Hi Adrian,

Please see the below explanation of the new proposed structural design, which should also be reviewed thoroughly with the drawing. We would also like to thank you for the provided extensions of time on this application.

Title: **FLOOR PLANS AND SECTIONS PROPOSED LAYOUT**

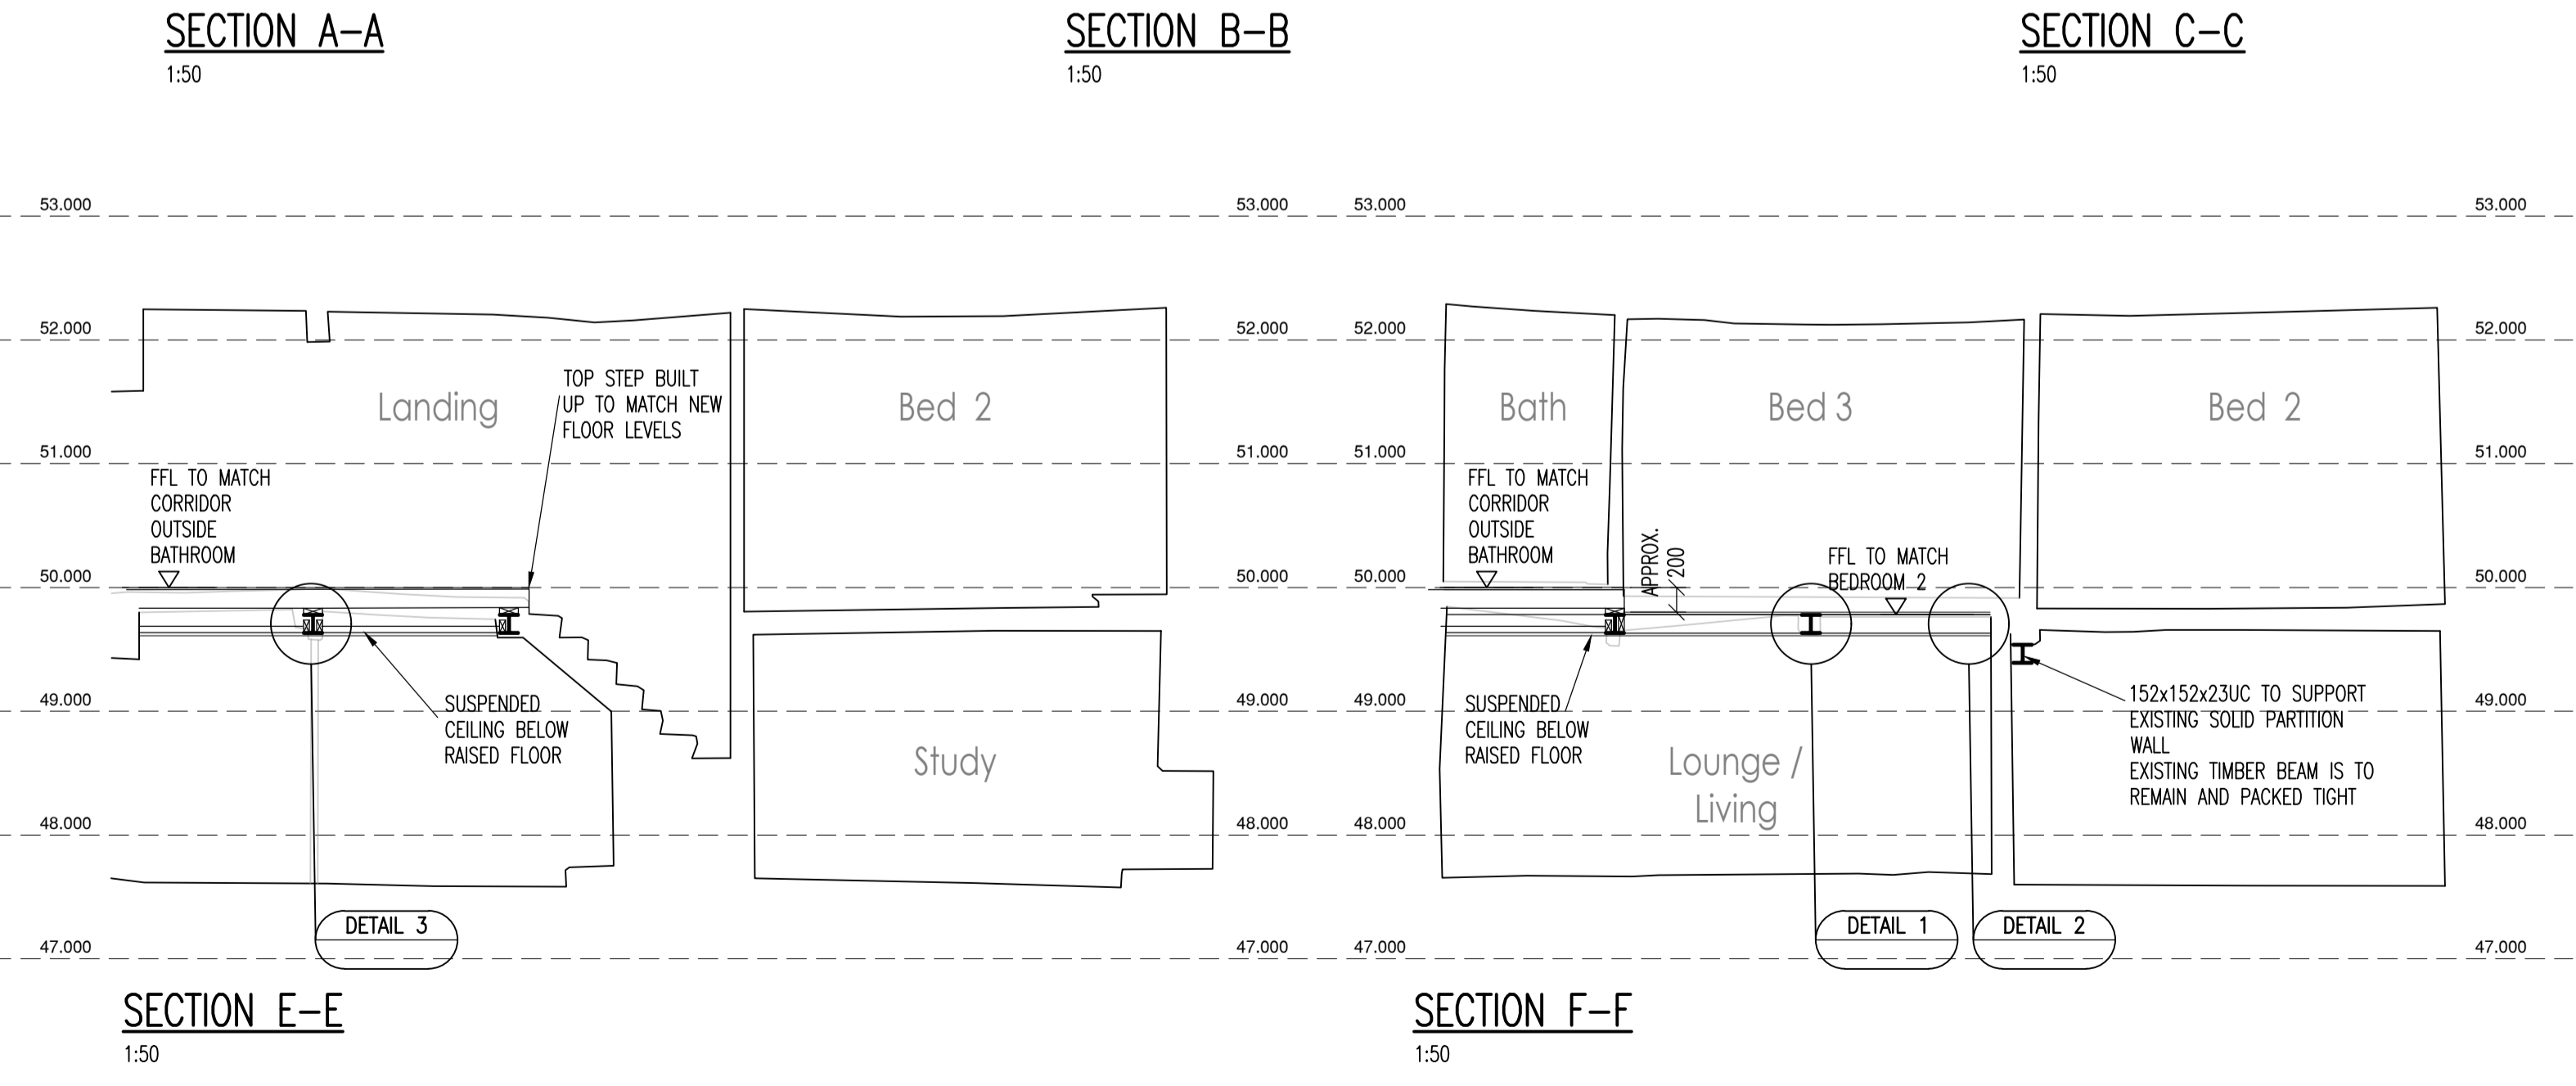
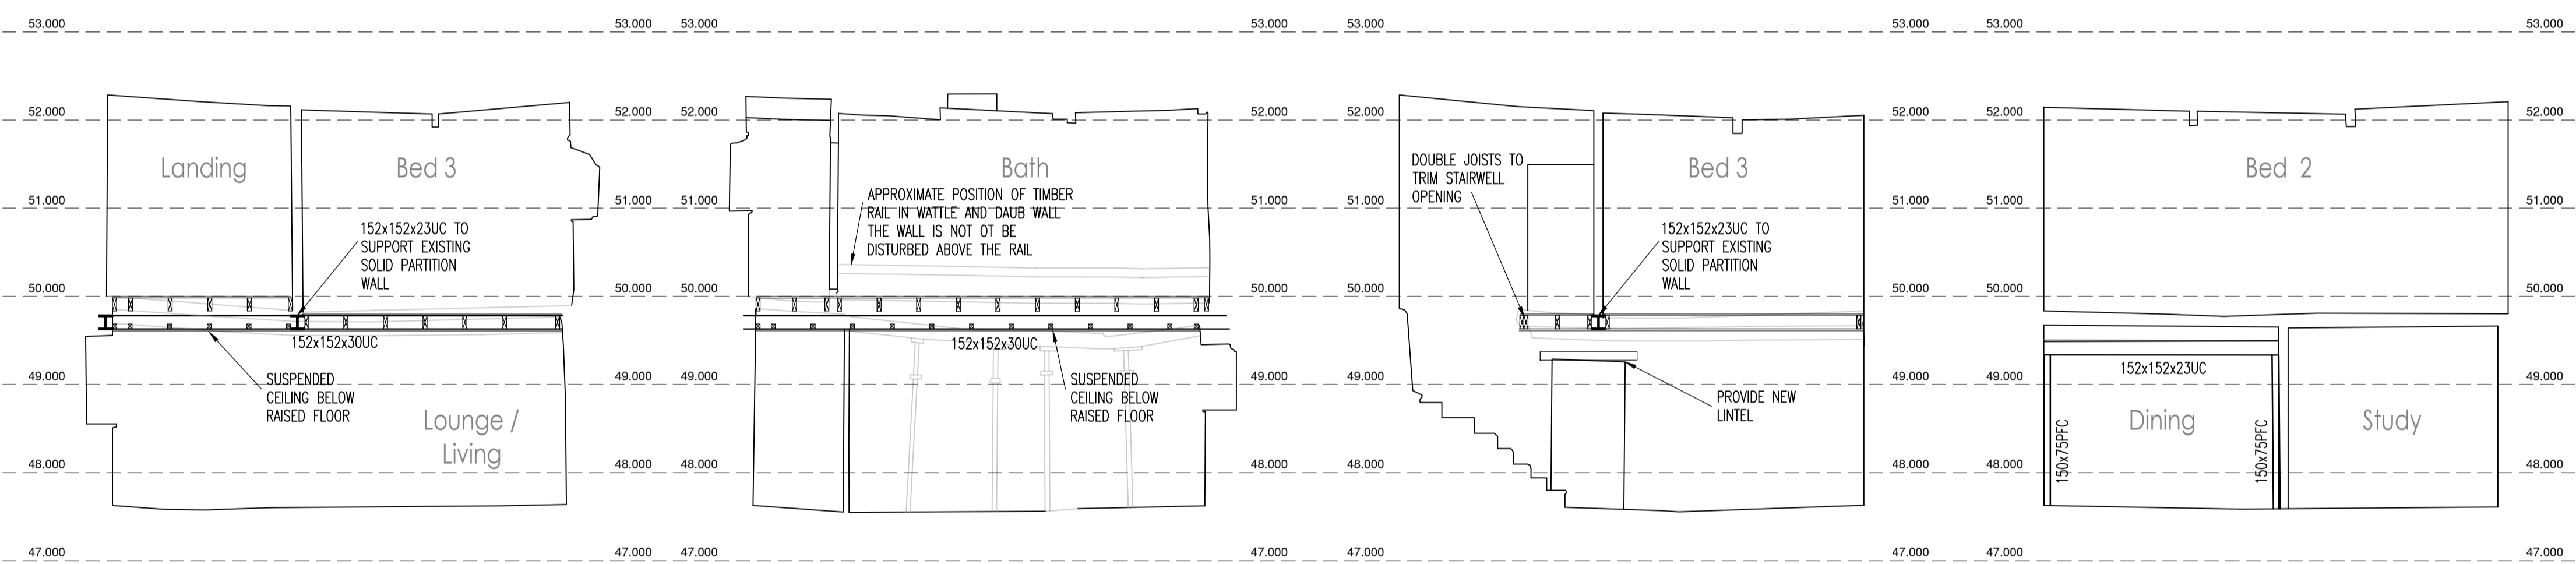
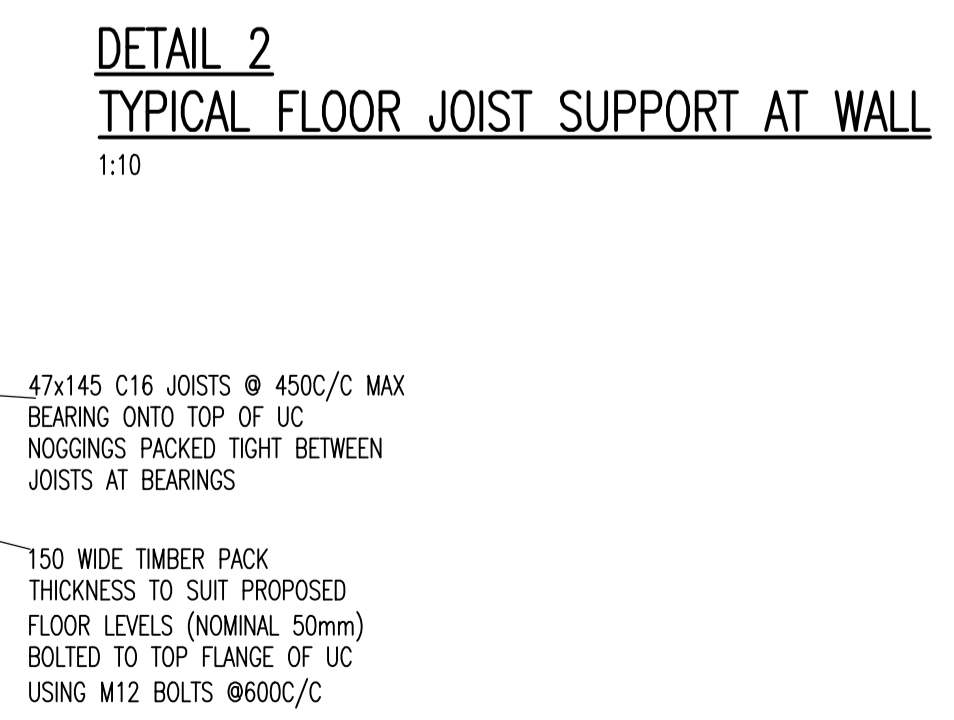
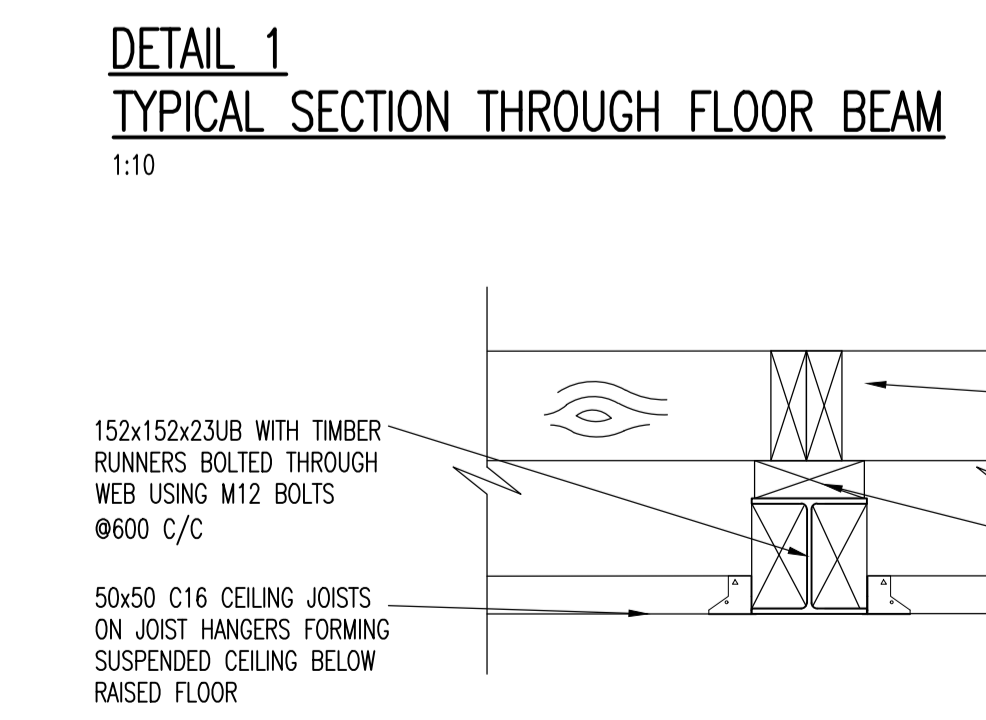
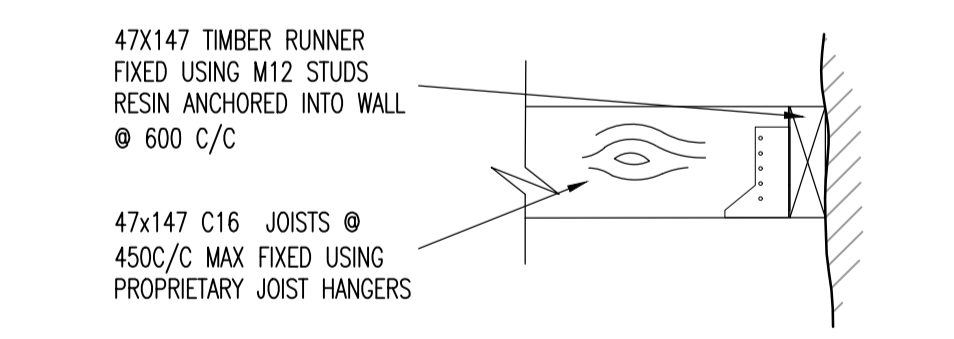
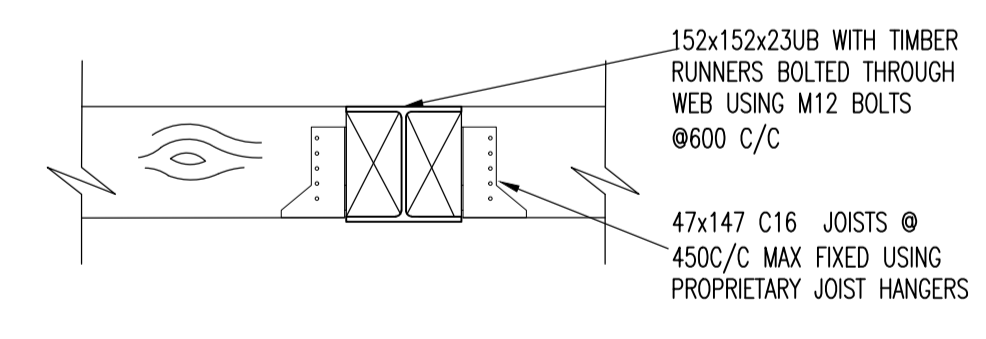
As shown on the attached drawing 10139-02-P7, the proposed structural design to beam 1 incorporates the use of 2 parallel flange channels (PFCs) measuring 150x75x18, which will be located either side of the wattle and daub partition, therefore causing minimal disturbance to the wattle and daub partition. These 2 PFC's will, so far as possible, be located beneath the built up floorboards used to level the existing floor and the original floorboards below. The PFC's will then be fixed to either side of the existing beam 1 using bespoke steel hangers, therefore fully supporting and retaining the beam whilst rendering it structurally redundant. Detail 1 provides a section showing the visual perspective of the above.

The PFC's will bear onto the existing walls below, there may be requirements for the installation of posts for further support but this can only be confirmed on site. Provisionally, 2 no. posts measuring 100x100x5.0 SHS have been allowed for and their potential locations are shown in the Part Ground Floor Plan section of the drawing. These would clearly require footings beneath the existing ground floor structure.

There is also the potential that the central pier of the rear window upon which the beam rests may need rebuilding to support the new steels being inserted, depending on its condition when opened up. This would only be undertaken if absolutely necessary. It should be noted that this location is to the pier between W4 on the joinery report. If required, this would be undertaken with a local sandstone in the closest possible matching appearance to the surrounding stonework.

As shown on the attached drawing 10139-02-P7, the proposed structural design to beam 2 no longer incorporates the use of a structural steel above. The new proposed repair is for the provision and use of oak packers for insertion into the shakes of the beam, with coach bolts to be used to secure the oak packers in place and provide further structural support in this beam. Detail 2 provides a section showing the visual perspective of the above.

As shown on the attached drawing 10139-02-P7, the proposed structural design to beam 3 in the dining room has not changed. The proposal is still to leave the existing beam in its place and insert a 152x152x23UC steel beam below to provide additional support to the solid wall above. Section F-F provides a section showing the visual perspective of the above.
